TfNSW Reference: SYD17/01529/15

DPE Reference: SSD 8859

AMENDED PLANS FOR ELIZABETH DRIVE SUBDIVISION AT 1111-1141 ELIZABETH DRIVE, CECIL PARK

Figure 9 | Final concept roadway and intersection design

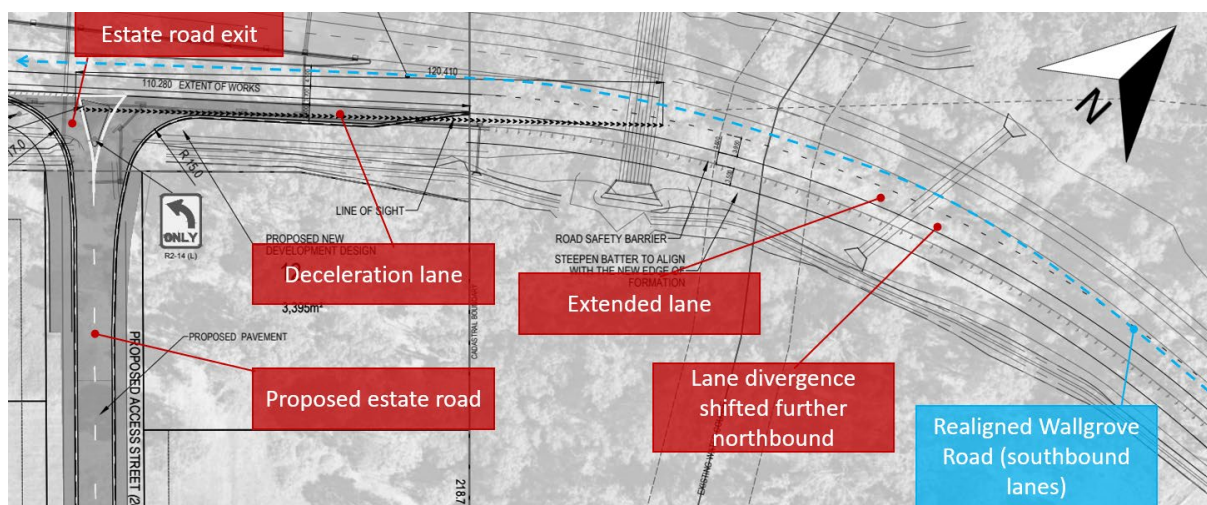
1. The proposed access arrangement necessitates redesign of future Wallgrove Road to ensure safe access and egress to/from the development site on Wallgrove Road.

The redesign works will include (but not limited to) line marking changes, minor widening of the proposed carriageway, localised steepening of the batters and may require an increase in pipe culvert lengths, in accordance with the attached sketch. The proposed access arrangement and the above required works (both design and construction) should be at full cost of the developer and no cost to TfNSW.

2. The proposed deceleration lane and the redesign works (described above) along future Wallgrove Road shall be designed to meet TfNSW requirements, and endorsed by a suitably qualified practitioner. The design requirements shall be in accordance with AUSTROADS and other Australian Codes of Practice. The certified copies of the civil design plans shall be submitted to TfNSW for consideration and approval prior to the release of the Construction Certificate by the Principal Certifying Authority and commencement of road works. Please send all documentation to development.sydney@transport.nsw.gov.au.
